July 11, 2019

Re: Project #PR-2019-002496 for Southeast Corner of Alameda Blvd. NE & Barstow Street NE

It has been brought to the attention of our Vineyard Estates Neighborhood Association that an application by Consensus Planning for a site plan on behalf of Philip Lindborg for development of 93 apartments on the southeast corner of Barstow Street NE and Alameda Blvd. NE is set for a Development Review Board hearing on July 17, 2019. It is our understanding that the property zoning is MX-L under the current IDO and this application is a permissive use of the property.

1. ANY BUILDING MOUNTED SIGNAGE IS TO BE ACHIEVED THROUGH A SEPERATE BUILDING PERMIT IN ACCORDANCE WITH THE UNDERLYING MX-1 ZONING

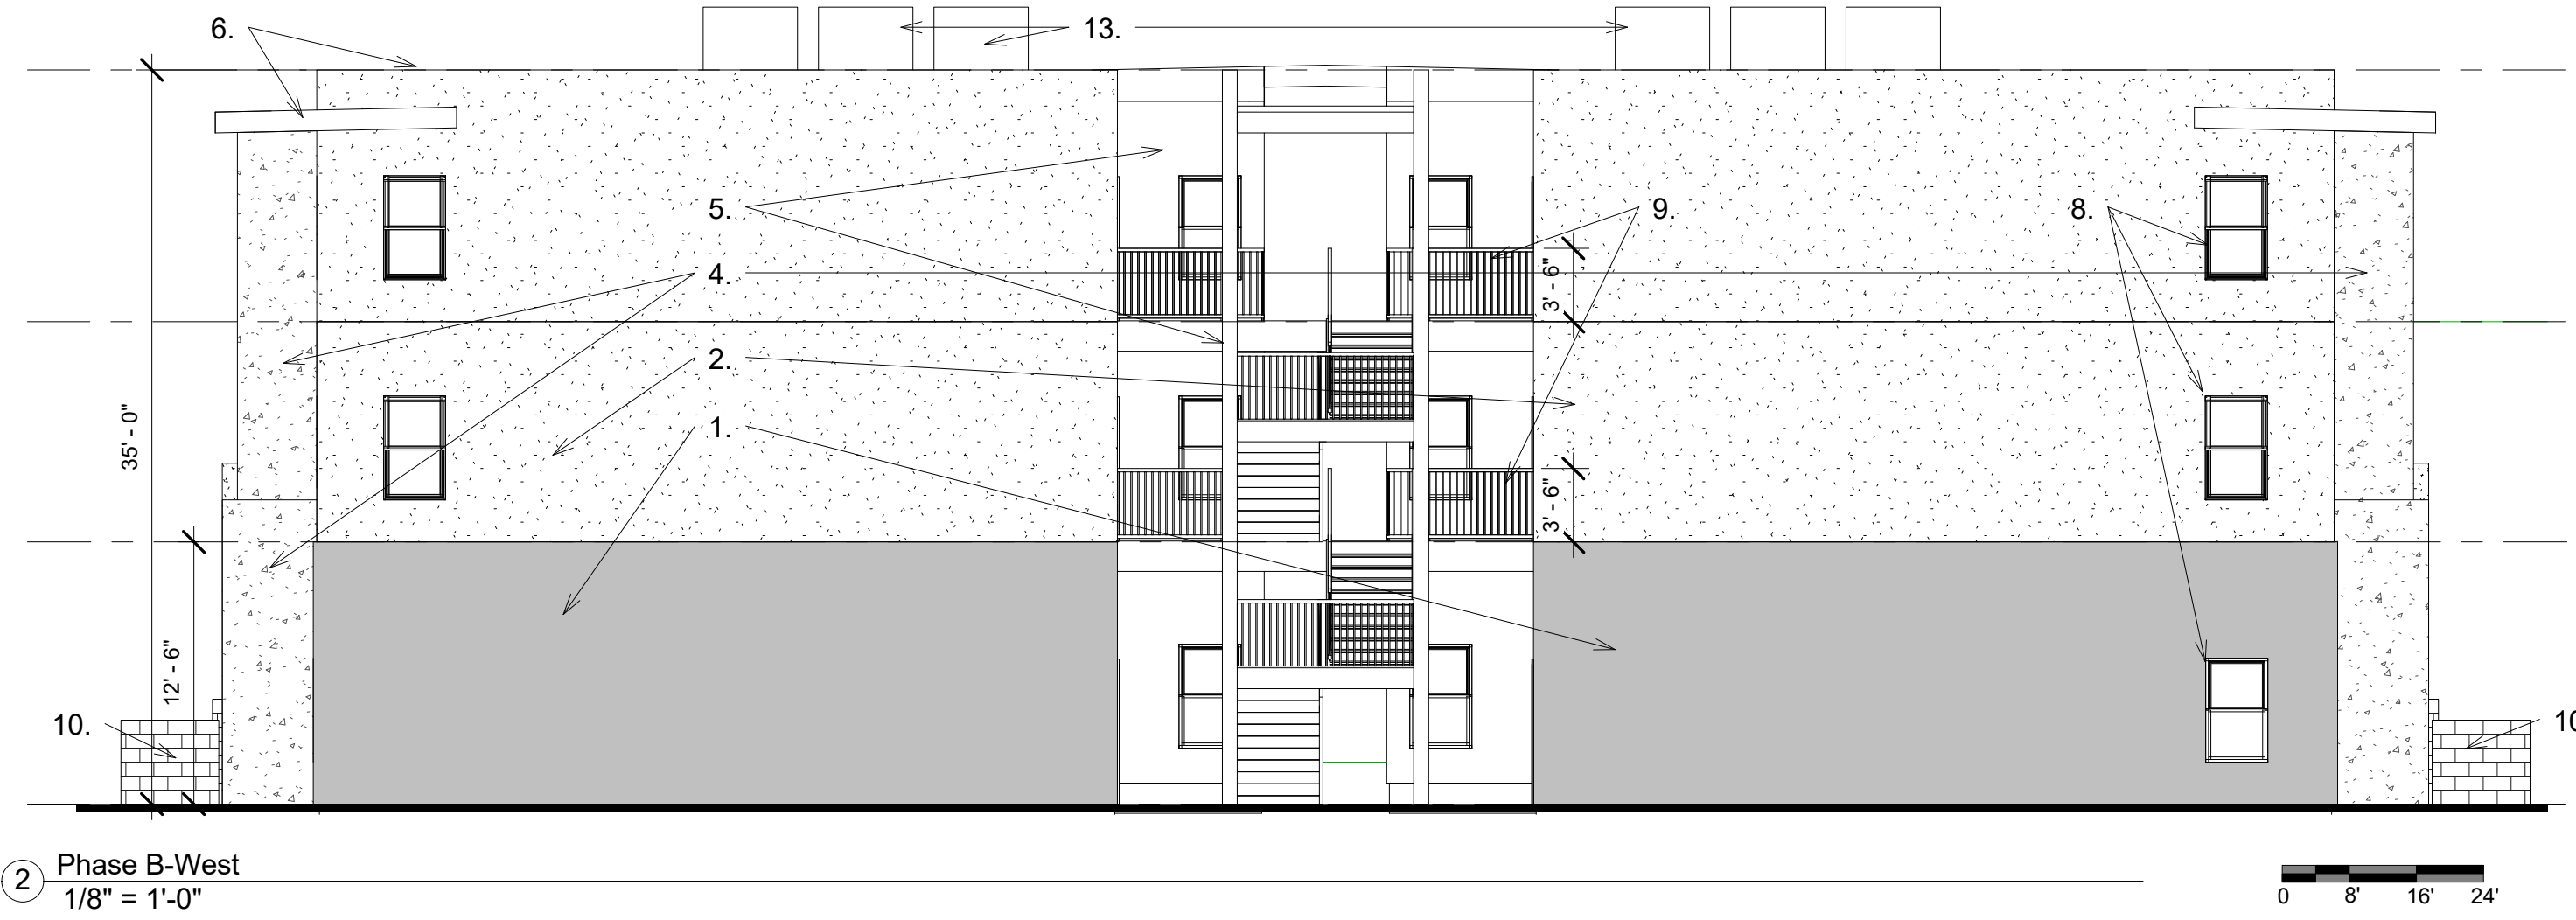
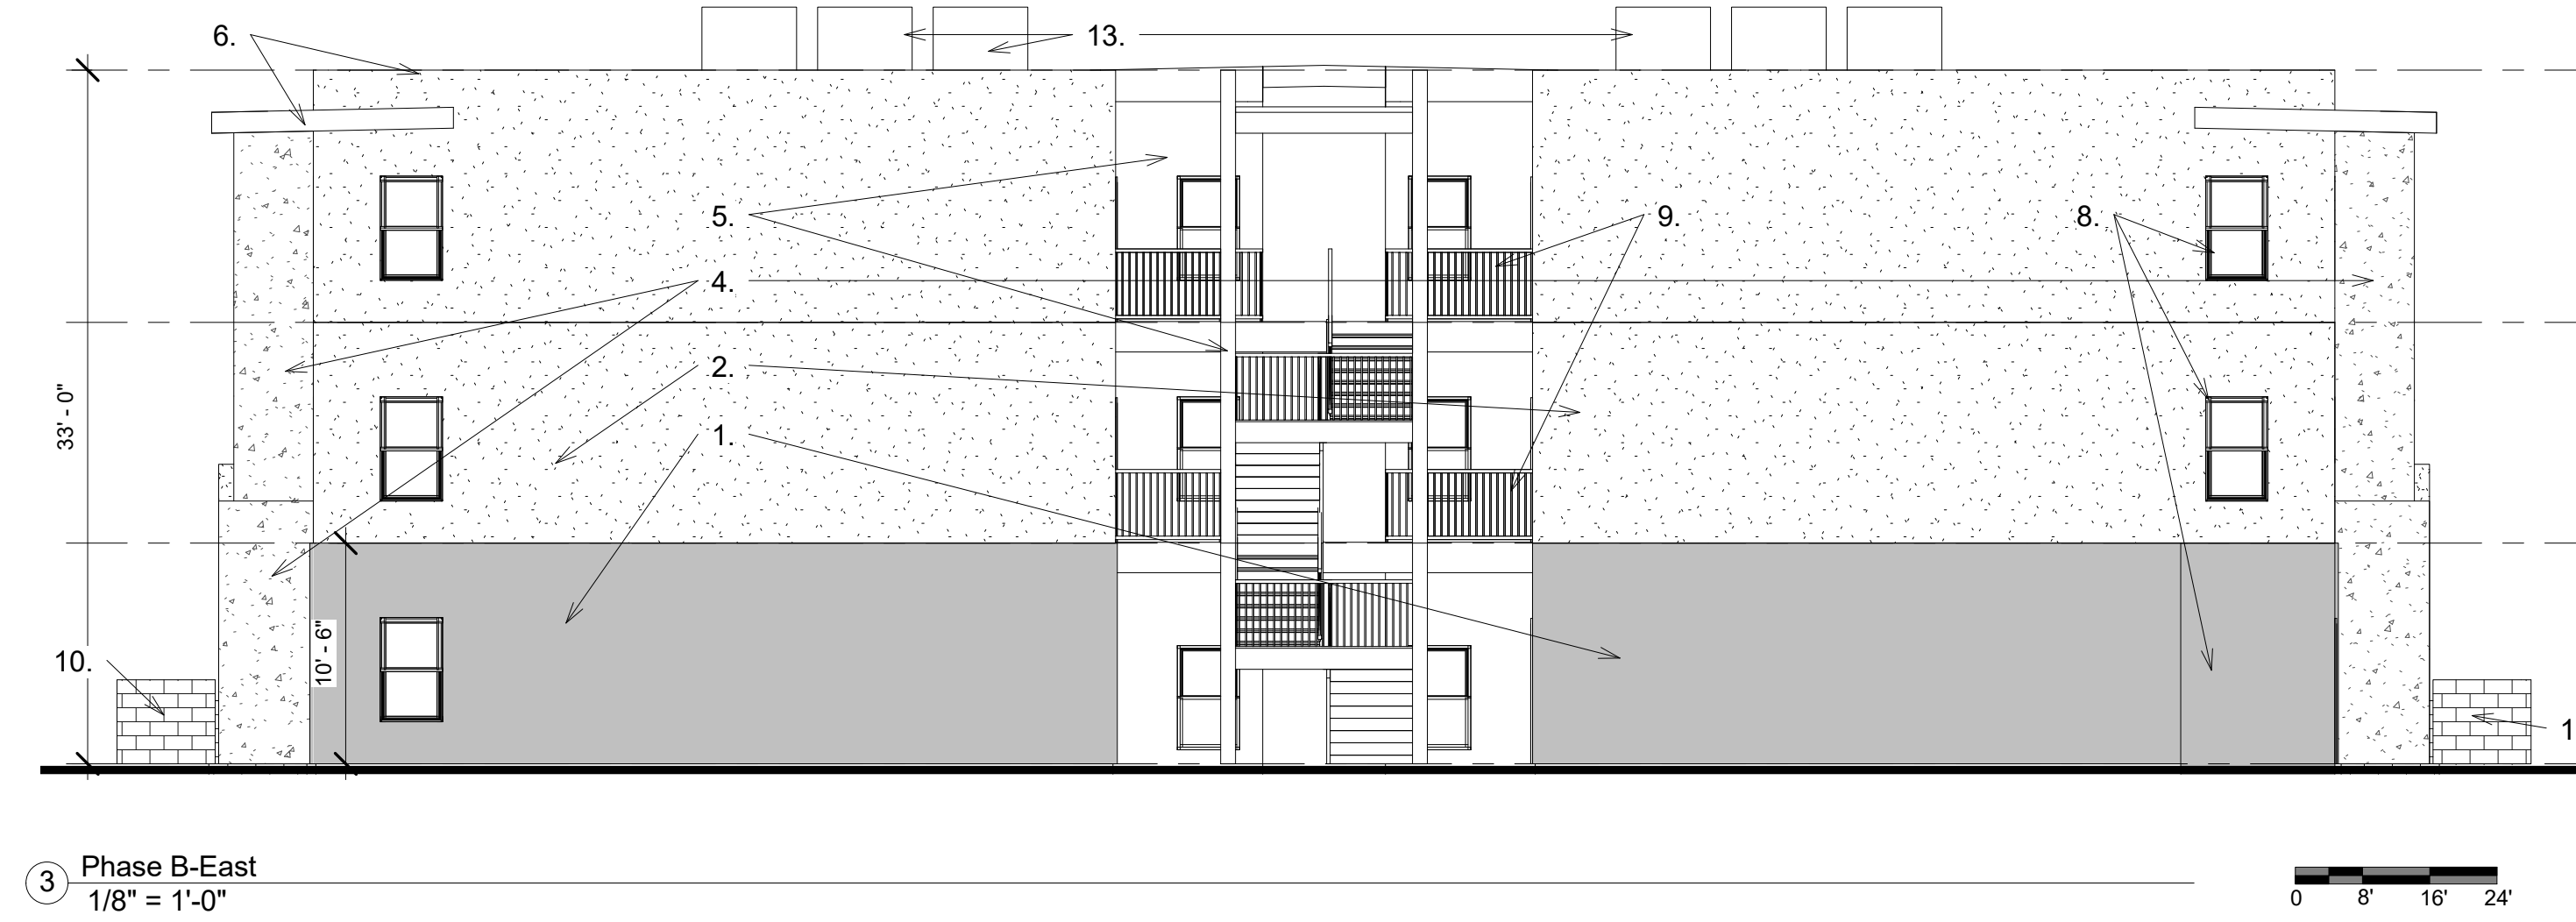
- 4) **Urban Design Style:** The design style of a 3-story, flat roof, brightly colored building (red, brown, orange, green per color-rendering Jeebs & Zuzu, Inc. provided documents) does not blend in with the surrounding earth tone homes (many of which have covenants clarifying appropriate paint color choices of which these colors would not be allowed) and gabled roofs of Tierra Morena (south-affected neighborhood), Pico la Cueva Place (north-affected neighborhood), and Tierra Montana Place NE (west-affected neighborhood). Use of black chain-link fencing as the security surround also does not fit with the tasteful design required by the surrounding neighborhoods’ covenants of stuccoed walls or wrought-iron gates/fencing to
